RE: IOOF Boundary Line Adjustment (BL-17-00006)

TO: All Staff
FROM: Justin Turnbull, County Surveyor 
DATE: May 9, 2018
SUBJECT: County Survey Review of BLA BL-17-00006 (IOOF)

PART OF STATE ADDITION AND PART OF THE NORTHEAST QUARTER OF SECTION 36, TOWNSHIP 18 NORTH, RANGE 18 EAST, W.M.

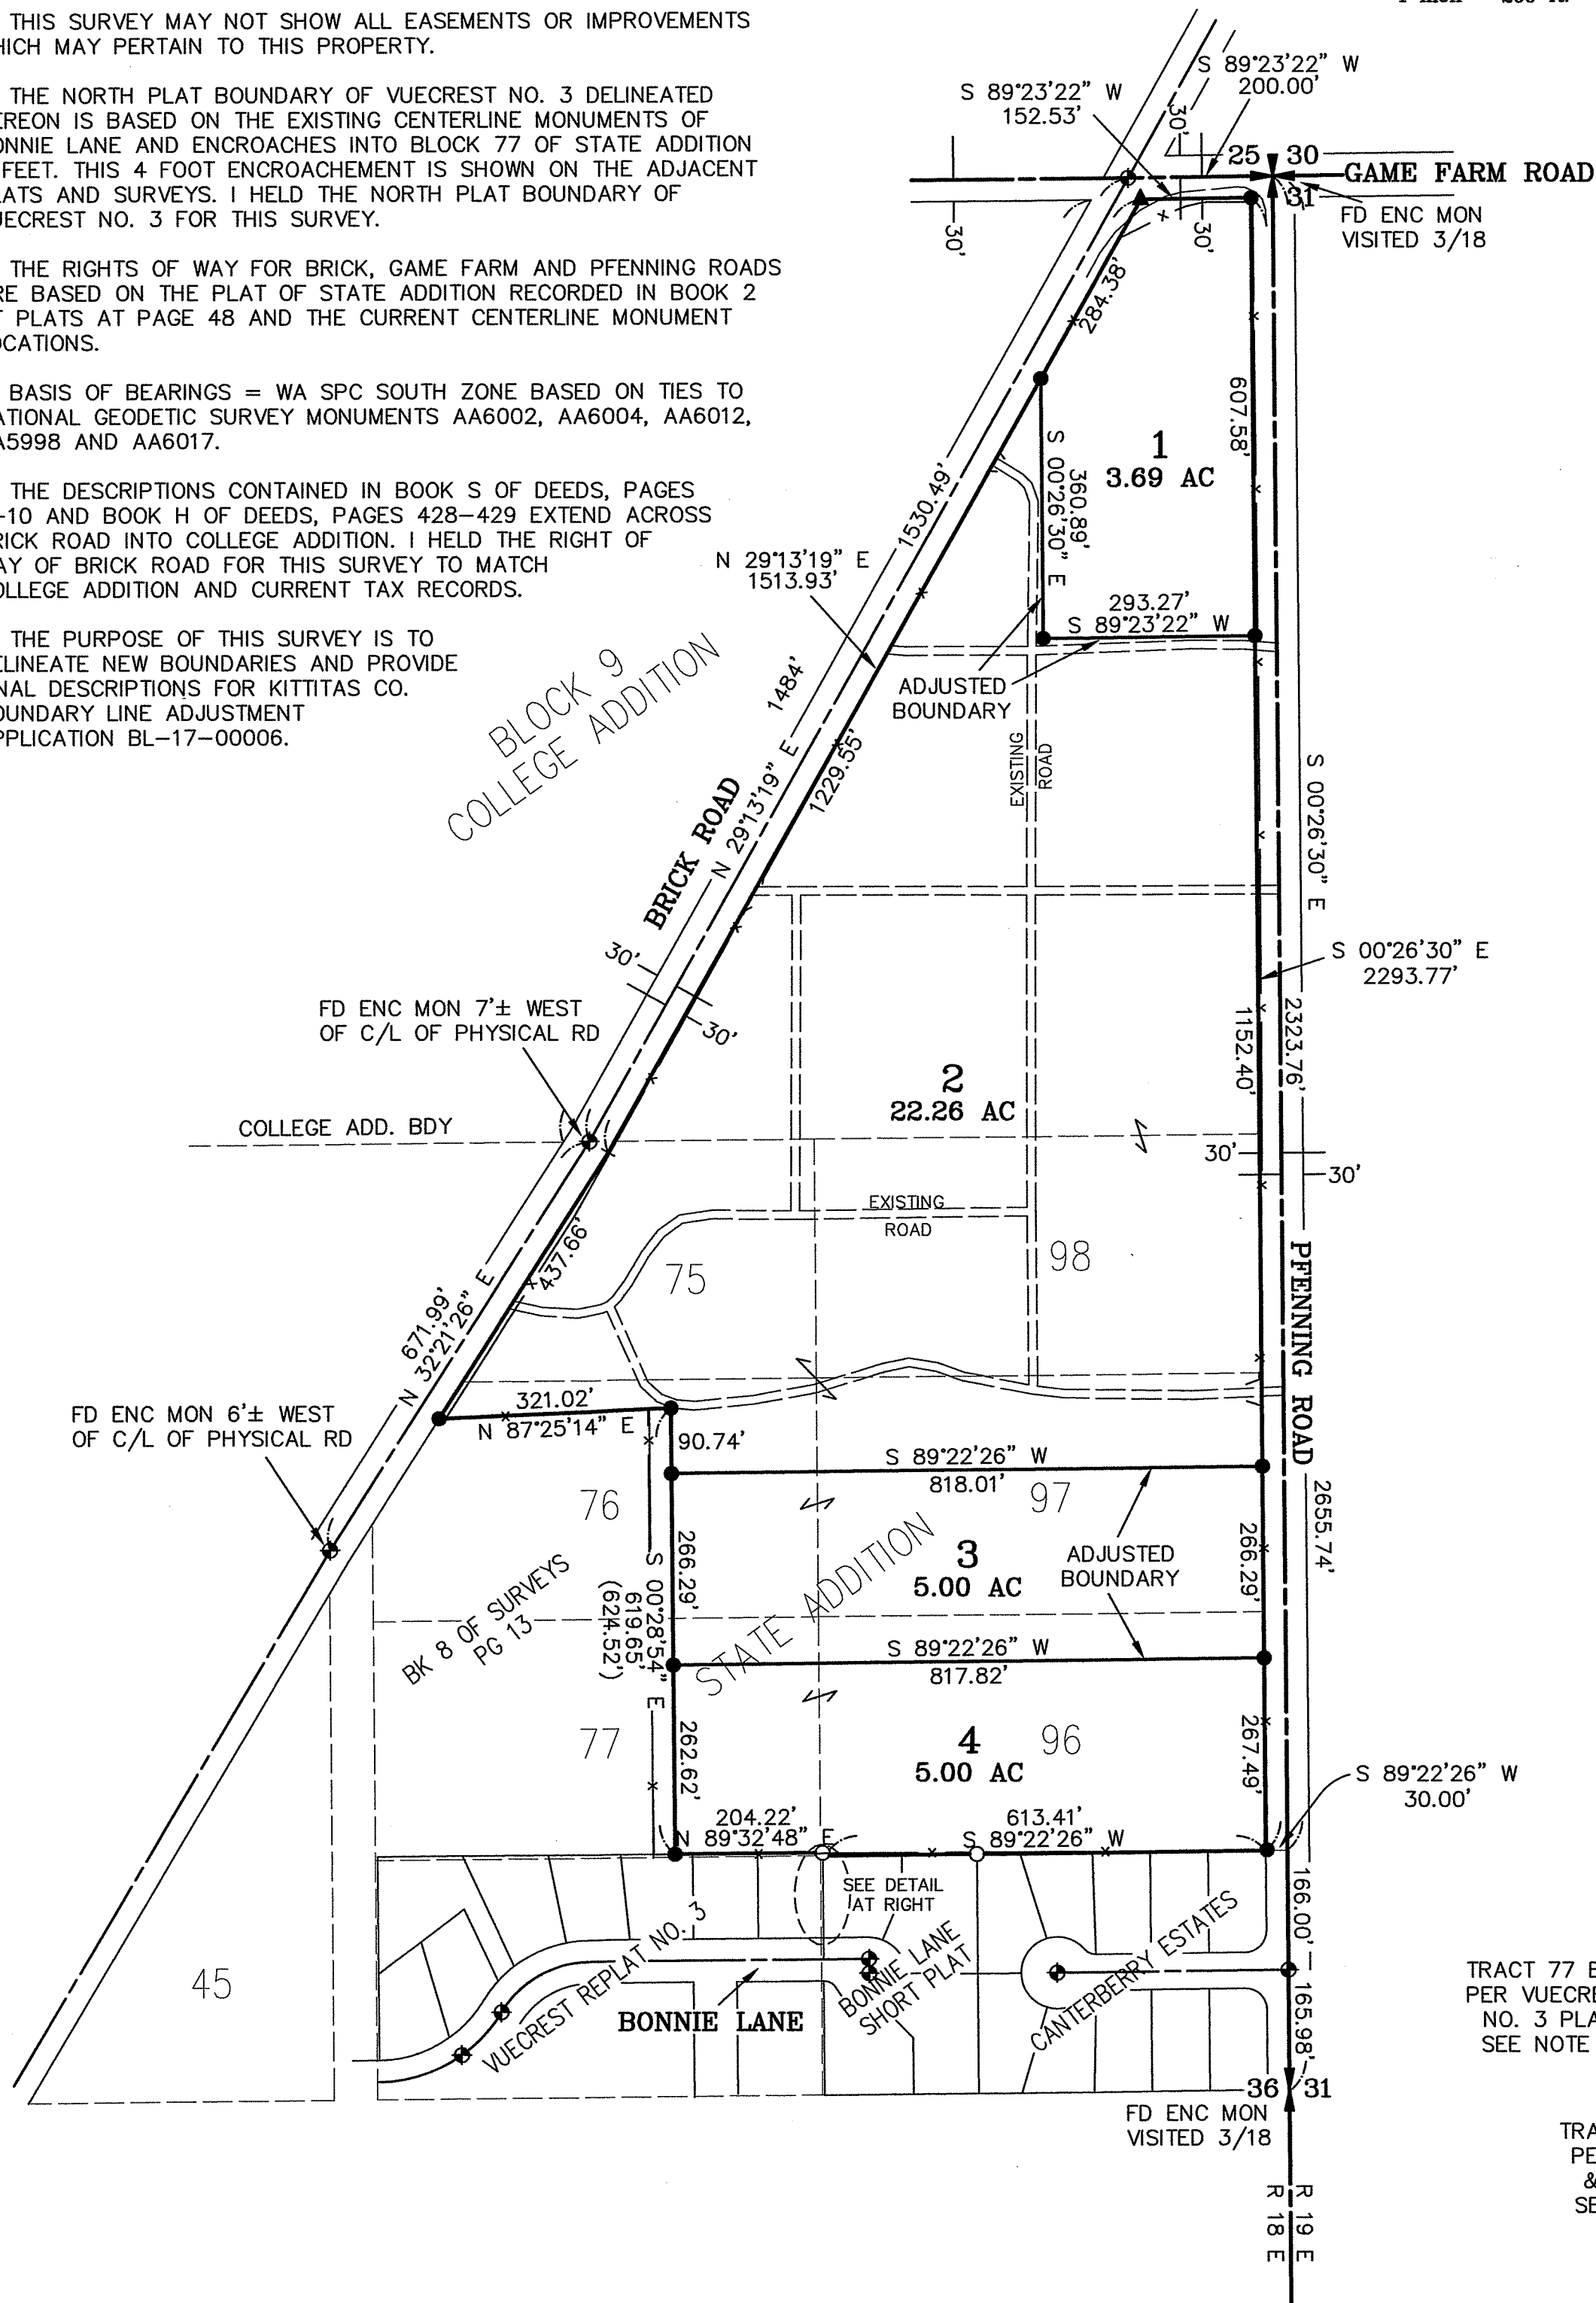
1. The existing legal descriptions shown are nonspecific in nature. Please correct.
2. Please note previous boundaries (or existing boundaries).
3. The dimensional tick (crowsfoot) for the section line are different sizes at each end.
